Recommendation Report for Planning Permission for Works or Extension to a Dwelling

REF NO: FG/100/19/HH

LOCATION: 23 West Drive
Ferring
BN12 5QZ

PROPOSAL: Single storey front extension

Proposed Floor Plan

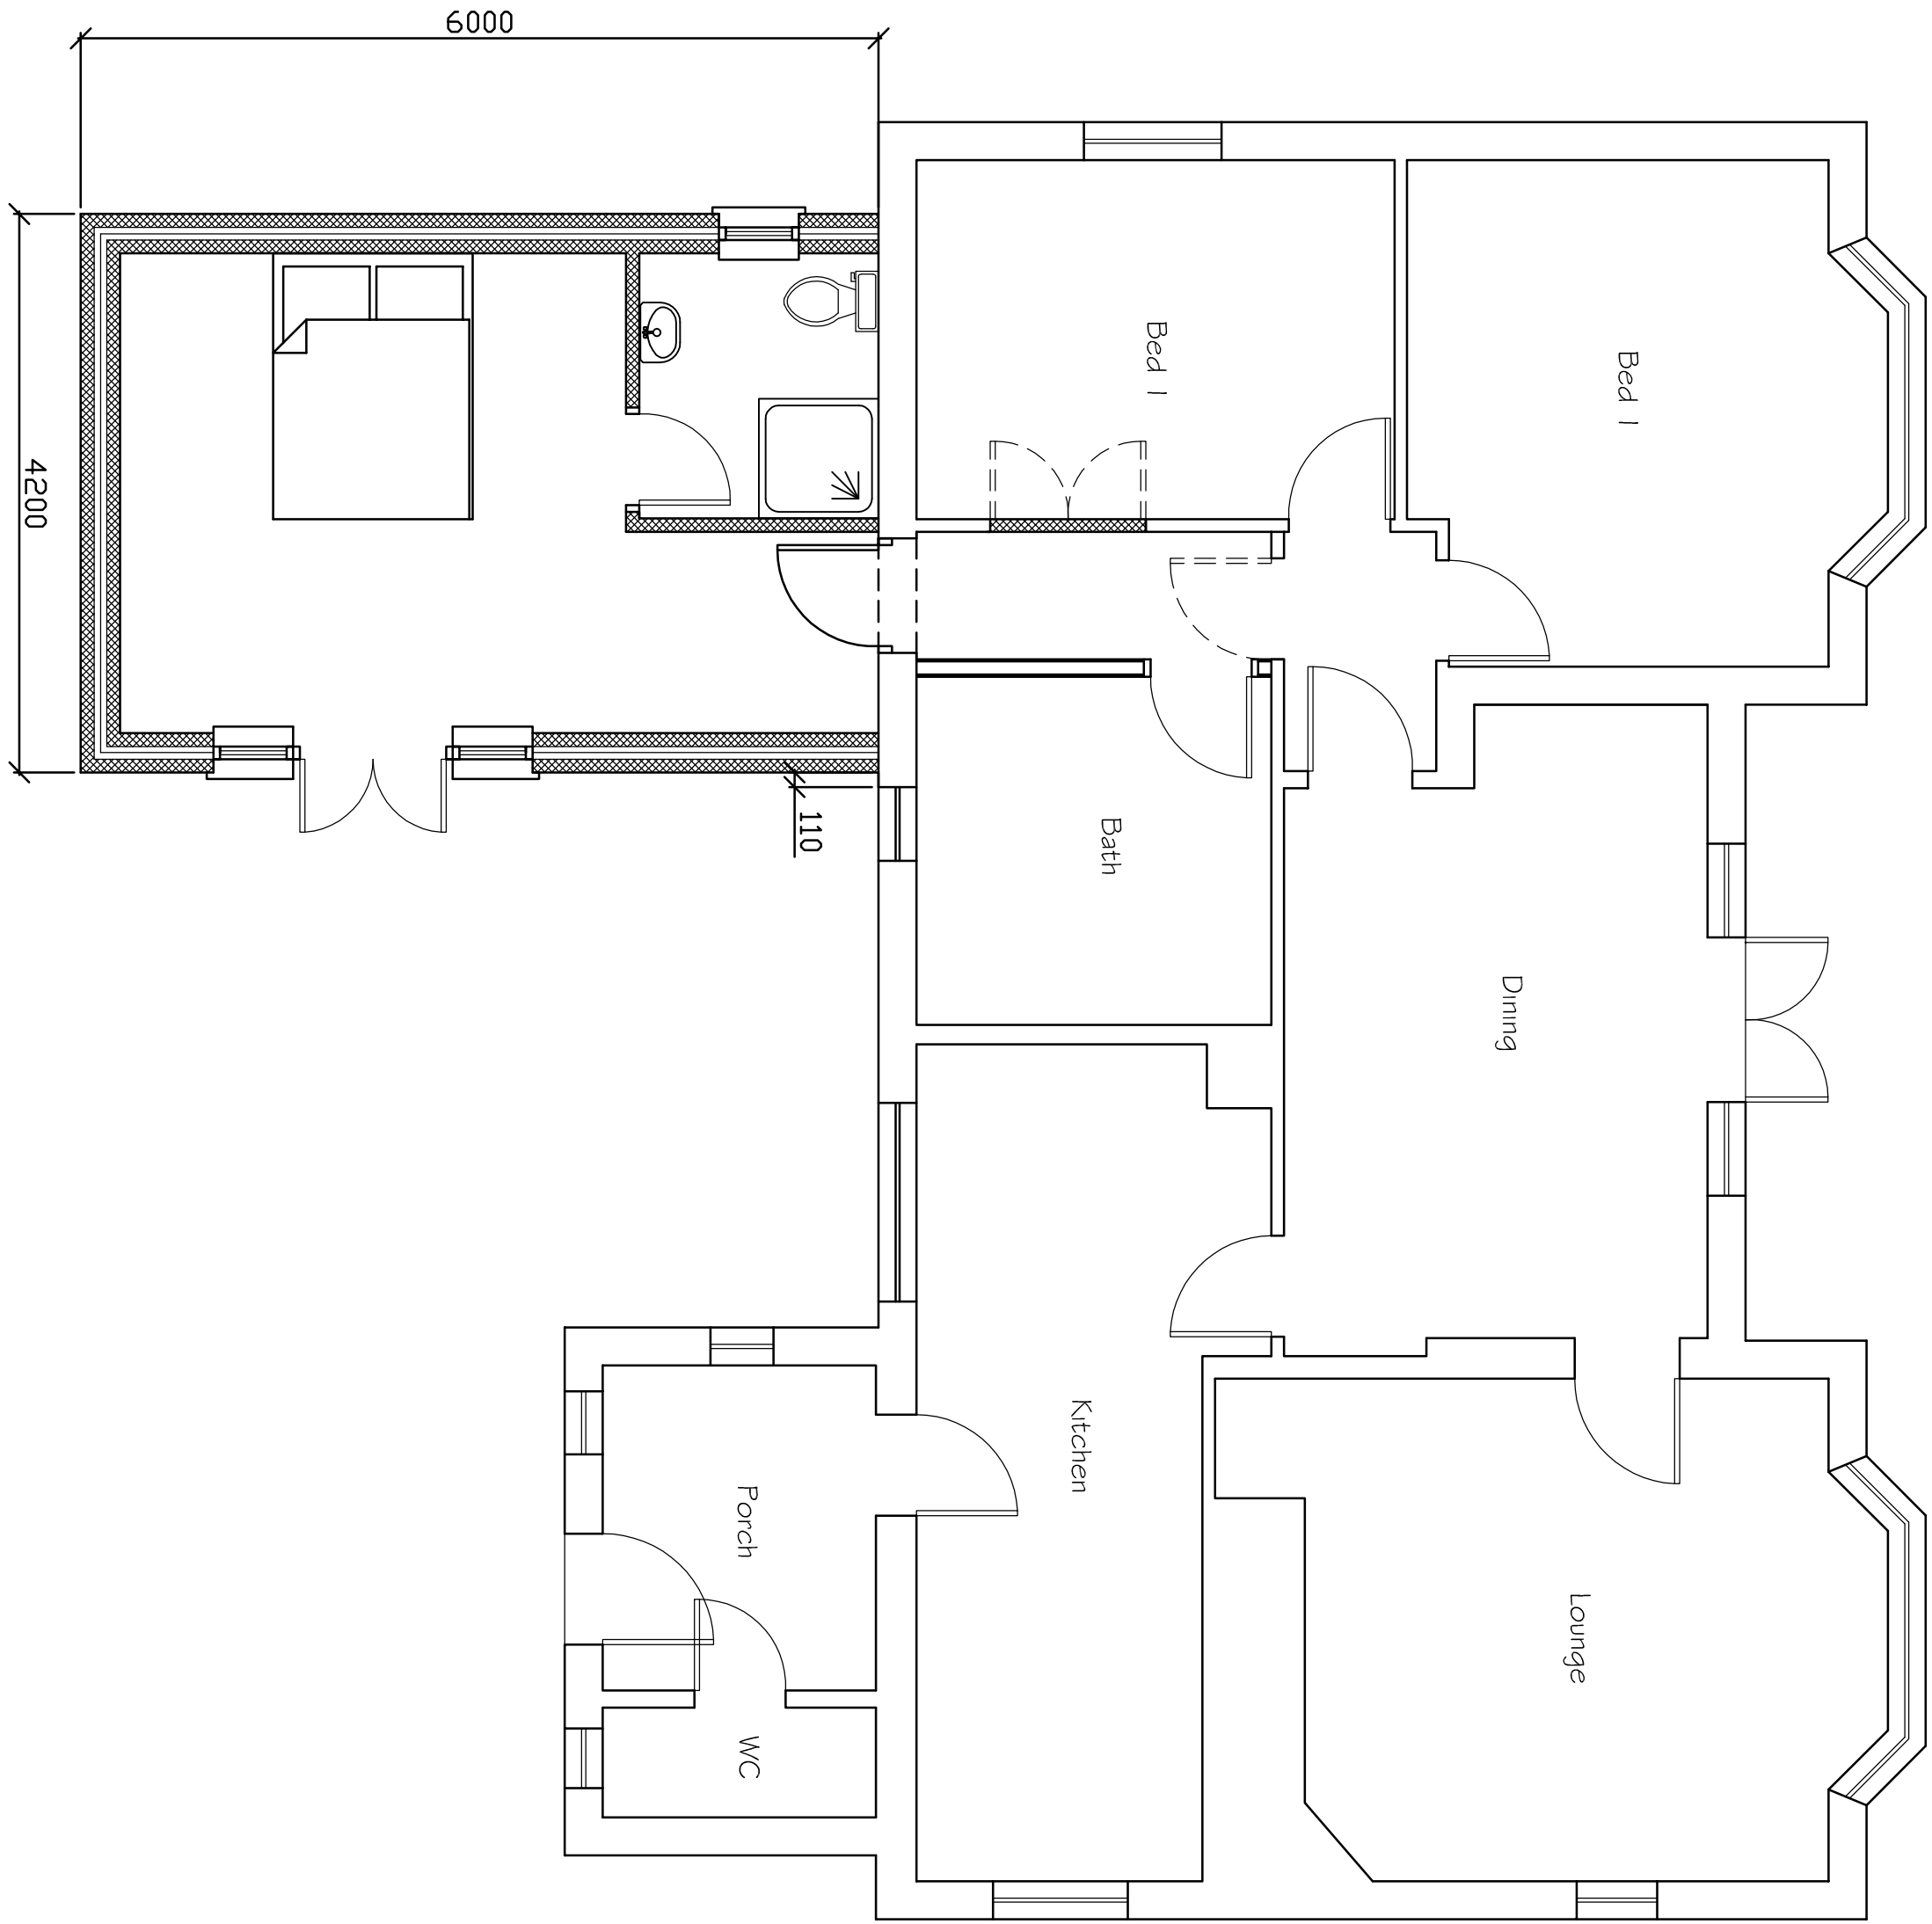
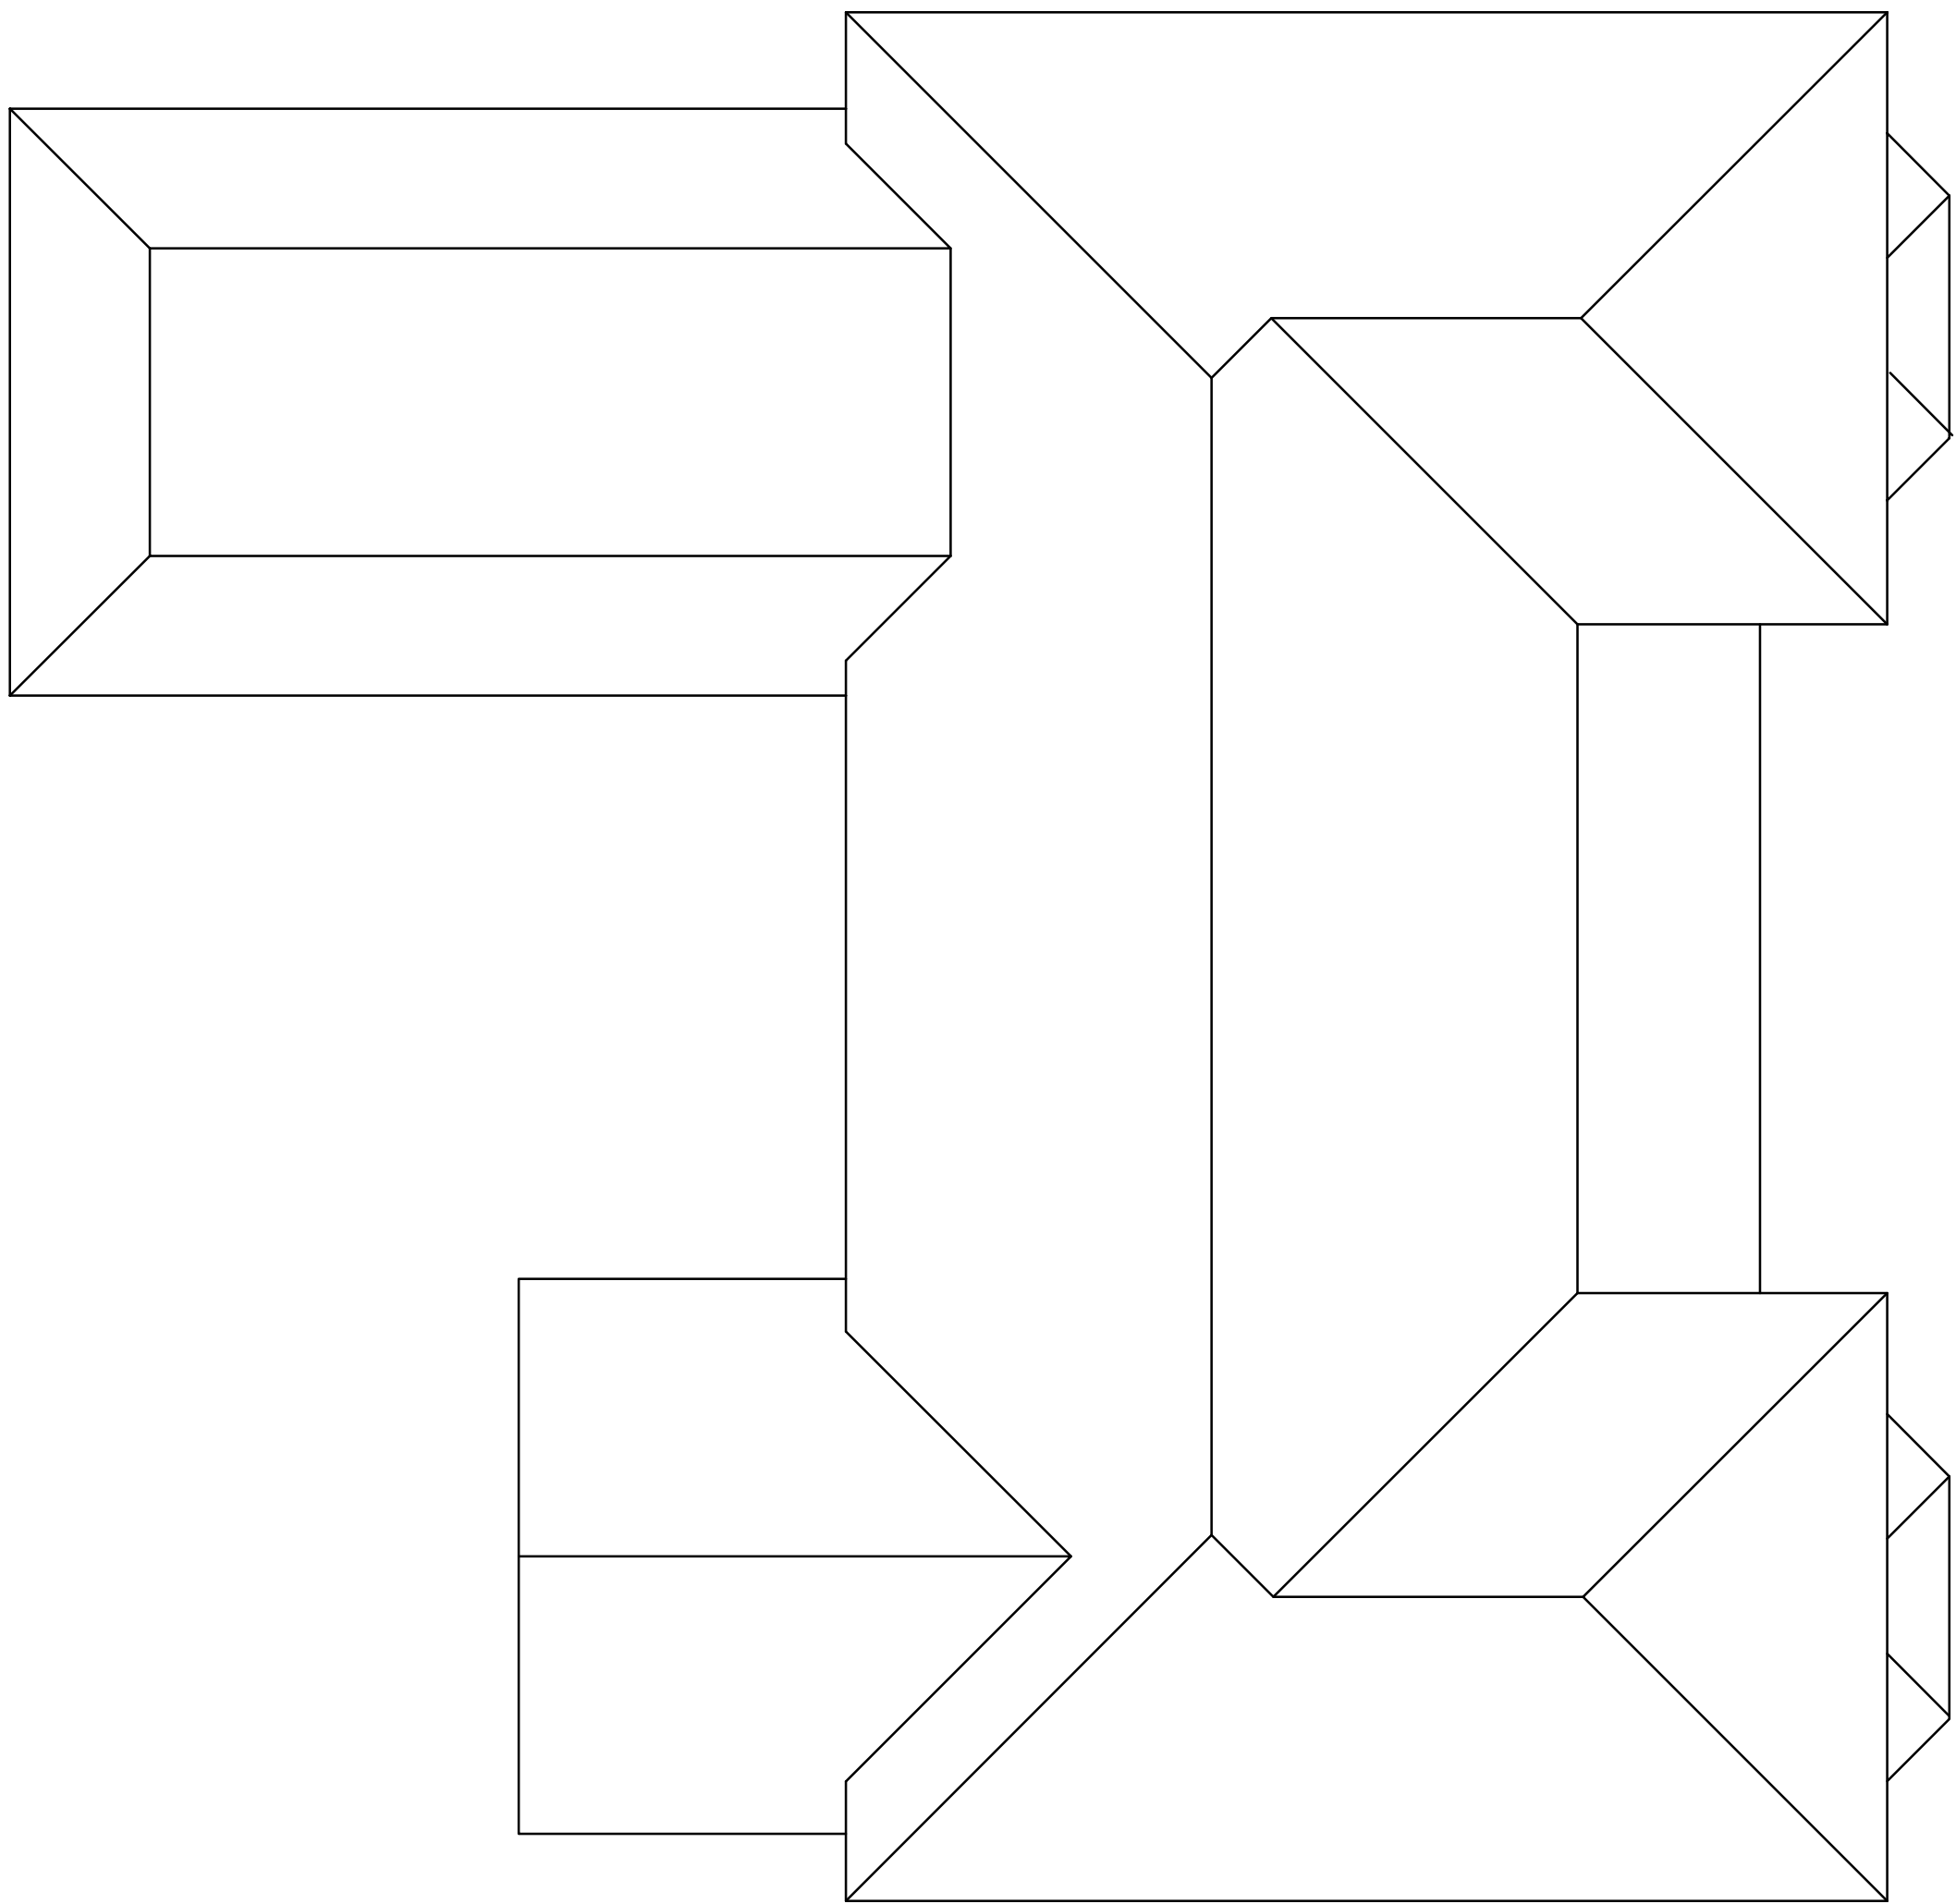
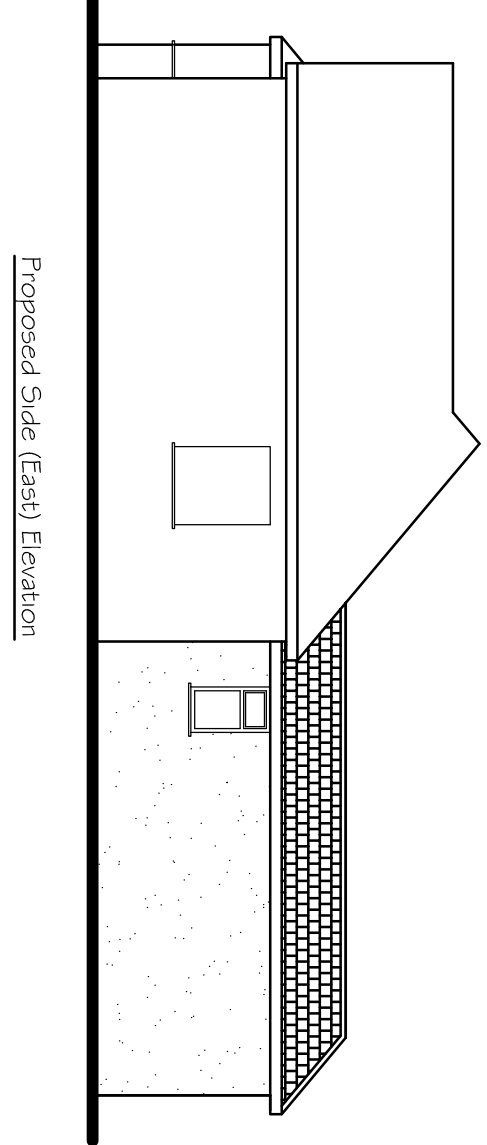
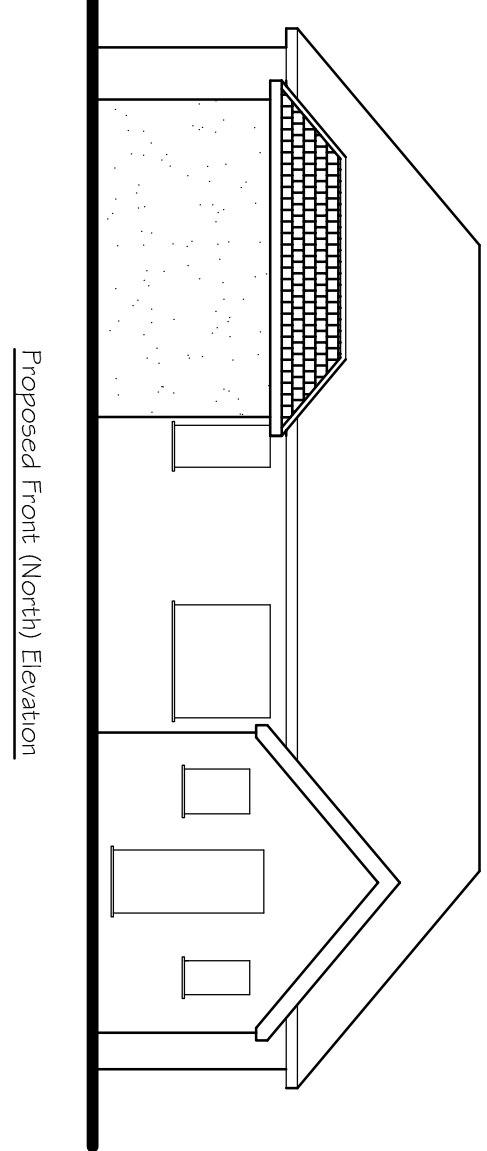
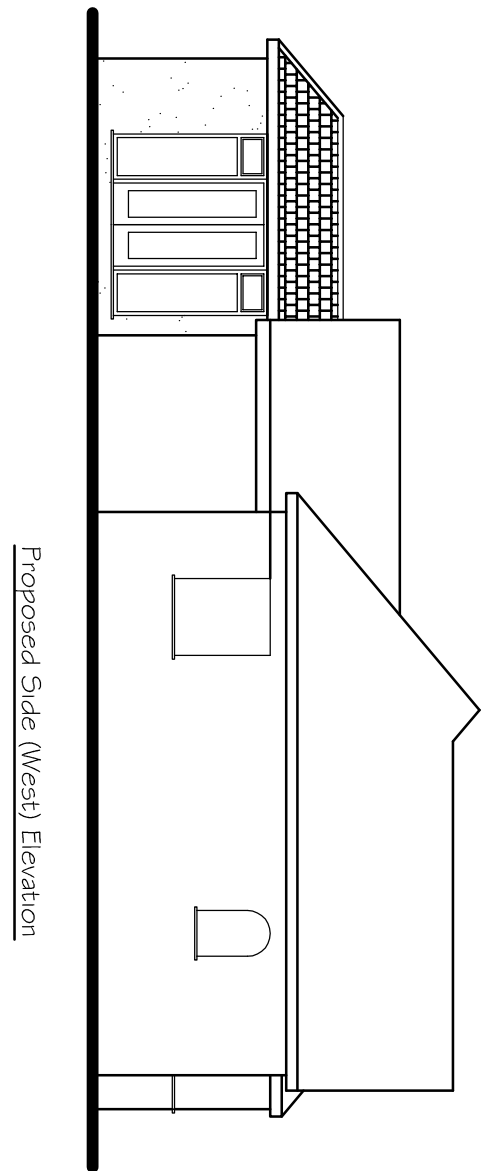
When considered within the context of the application site, the proposed development will have an awkward relationship, be bulky and poorly integrated to the host dwelling. This is largely as a result of its siting and design creating an unbalanced, unsymmetrical Northern elevation. The existing Northern projection to the host dwelling, forming a porch and WC has a pitched roof, and only extends 2.3m from the front elevation of the dwelling. On comparison, the proposed development has a partial flat roof, with sloped sides, extending 6m from the front elevation of the host dwelling. Therefore, the proposed extension is considered to be in conflict with D DM4(a) of the Arun Local Plan.

The proposed rear extension is considered to result in a significantly harmful impact upon the residential amenities of neighbouring dwellings. It is considered that as a result of the scale, and proximity of the rear extension to the Eastern boundary of the application site, it will have an overbearing impact on the occupiers of the property directly to the East, #14 The Poplars.

The proposed extension is at a height of 3.3m, which is approximately 1.4m above the height of the

boundary treatment fencing between the application site and 14 The Poplars at a distance of only approximately 1.7m from the boundary line. At a length of 6m, this is considered to result in a significantly harmful overbearing impact upon the occupiers of 14 The Poplars particularly as it would span the full width of their private amenity land. With regard to loss of privacy through overlooking, all of the proposed openings are at ground floor level, and therefore, do not provide any views different to those available from the application site at current. The proposed development is considered to be in conflict with D DM1(3) and D D DM4(c) of the Arun Local Plan, due its detrimental impact on the occupiers of the dwelling to the East of the application site, by way of overbearing, and overshadowing.

- 1 The proposal, due to its height, length and siting, will have an unneighbourly overbearing effect on the occupiers of #14 The Poplars, Ferring, in conflict with D DM1(3) and D DM4(c) of the Arun Local Plan and Policy 1a of the Ferring Neighbourhood Development Plan.

- 2 The proposed extension, due to its scale, design and siting is considered to appear awkwardly integrated with the host dwelling, in conflict with D DM4(a) of the Arun Local Plan and Policy 1a of the Ferring Neighbourhood Development Plan.
